DRB Project Number: PR-2018-1580 (1005234)
Application Number: SI-2018-00153
Project Name: Hotel Wyndam – Apartment Conversion

EXHIBIT 'A' – Response to comments

18007 AS101

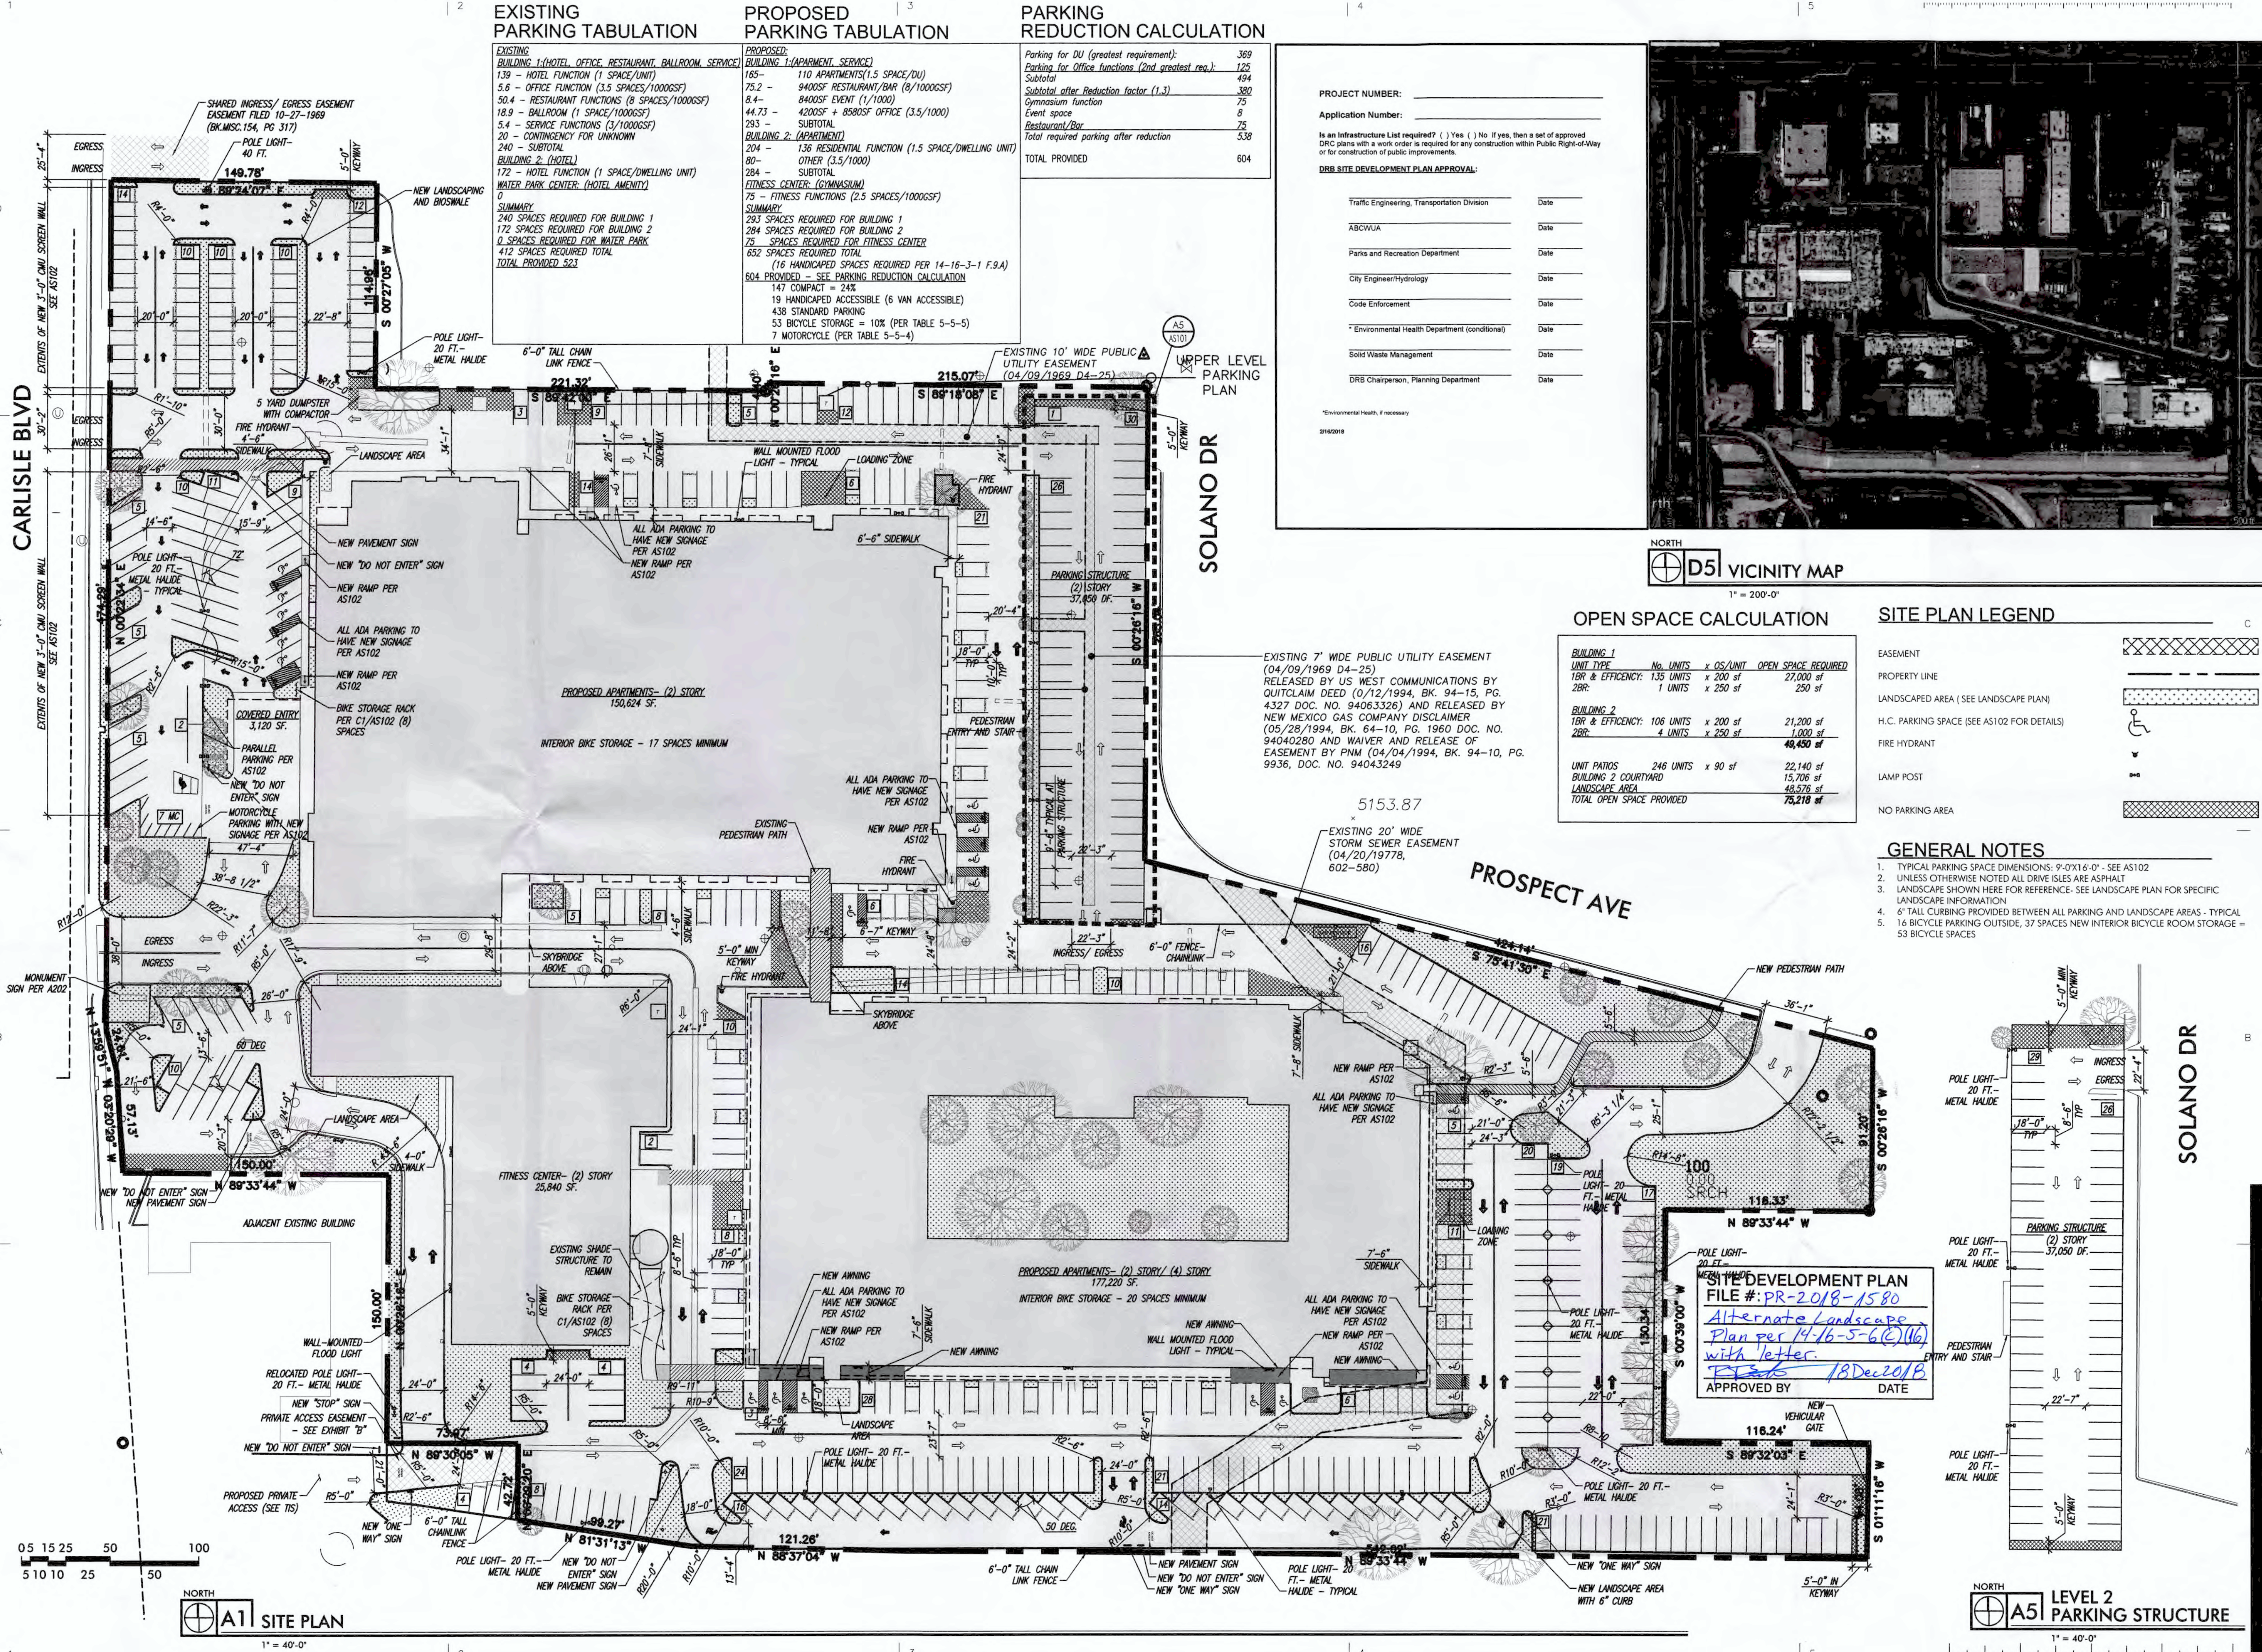
1. *Parking calculation is missing for ADA, and motor cycle parking.*
 - a. **ADA and motorcycle parking calculations have been added to the drawings.**

2. *Please indicate two-way entrance by placing arrow.*
 - a. **Arrows have been added to the entrances where applicable.**
3. *Some entrances lack dimensions. Please provide dimension for all access roads.*

- a. **Entrance dimensions have been added to the drawings.**
4. *Please indicate which drive way is one way and which is two way using arrows.*
 - a. **Directional arrows have been added to the drawings.**

5. *Please list the width and length for all existing and proposed parking spaces. Some dimensions are not shown.*
 - a. **Parking space dimensions have been added in numerous locations – any anomalous dimensions have been noted. Standard dimensions are also indicated on standard details on AS102.**

6. *The ADA accessible spaces must be a minimum of 8.5 ft. in width.*
 - a. **ADA accessible spaces have been verified as at least 8.5' in width.**
7. *The ADA accessible spaces must include an access aisle. Van accessible aisles should be 8ft wide; all others should be 5ft wide.*

- a. **Detail and sign locations are now indicated in the drawings.**
9. *The ADA access aisles shall have the words "NO PARKING" in capital letters, each of which shall be at least one foot high and at least two inches wide, placed at the rear of the parking space so as to be close to where an adjacent vehicle's rear tire would be placed. (66-1-4.1.B NMSA 1978)*

- a. **Signage is noted on plan. Sign detail is located on AS102.**
- 12. *Show all drive aisle widths and radii. Some dimensions are not shown.*
 - a. **Width and radii of drive aisles have been added to the drawings.**

- 13. *A 5 ft. keyway is required for dead-end parking aisles.*
 - a. **Any dead end locations have been equipped with a 5' minimum keyway.**
- 14. *Provide a min 6" or max 8" high concrete barrier curb or other acceptable barrier between landscaping and parking areas and/or drive aisles. Please call out detail and location of barrier curb.*

- a. **Signage for "One Way" and "Do Not Enter" have been added to the Site Plan where one-way traffic conditions exist.**
- 16. *Show existing curb gutter and sidewalks on all roads.*

- a. **Curb and Gutter along Solano/Prospect have been added to the Site Plan drawing.**
- 17. *Please show the second level plan for the parking garage.*

- a. **Calculations added to the Site Plan.**
- 4. *Pedestrian paths shall be provided between the pedestrian entrances of each primary building on the site per 14-16-5-3(B)(3)(b).*

- 5. *Such network of pedestrian paths must include a connection to the adjacent public sidewalk(s).*
 - a. **Proposed connections from Building 1 to Carlisle Blvd. and from Building 2**

8. *Parking calculations do not appear to be 100% accurate. Ensure accurate calculation of existing and proposed for each building. Applicability criteria indicate IDO parking requirements are only triggered for this request if the change of use of a primary building increases the parking requirement by more than 25 percent. This does not appear to be the case for the hotel buildings, but potentially the waterpark to fitness center conversion. Depending on final calculations, staff will evaluate the remainder of the requirements in 14-16-5-5, or we can provide additional comments as suggestions to comply ahead of any potential future building addition that could also trigger such requirements.*

19. *Not all light pole locations are shown. Please show all locations and include height or provide standard detail. Are new lights proposed? If so, max 20' height and lighting rules apply to the new or replacement fixtures.*

21. *Please show existing freestanding signs and size/detail. These signs may be nonconforming. Are any new freestanding signs proposed?*

- a. **"NO PARKING" annotation added to the Site Plan.**
10. *ADA curb ramps must be updated to current standards and have truncated domes installed.*
 - a. **Non-compliant ramps have been revised in the drawings per current standards. Details articulating truncated domes are indicated on AS102.**

- a. **A General Note indicating a minimum 6" curb separation of landscaping from parking has been added to the Site Plan.**
- 15. *One-way vehicular paths require pavement directional signage and a posted "Do Not Enter" sign at the point of egress. Please show detail and location of posted signs.*

- a. **The second level parking garage plan is now indicated on the Site Plan drawing.**
- 18. *Provide details for the rectangular spaces in Prospect Ave.*

to Prospect have been added to the Site Plan drawing.

- a. **Parking calculations have been revised and annotated on the Site Plan.**
9. *Will there be office space in either of the apartment buildings? Office has a different calculation than "Service uses." Water park may be considered "other indoor entertainment" and be subject to parking requirements in Table 5-5-1 and/or Table 5-5-2 even if it was previously approved without parking as an amenity to the hotel.*

- a. **All exterior pole and building mounted site lighting have been located and noted on the plan. No new lighting is planned.**

a. Existing freestanding signs are estimated and indicated on drawings. No new signs are being proposed at this time.
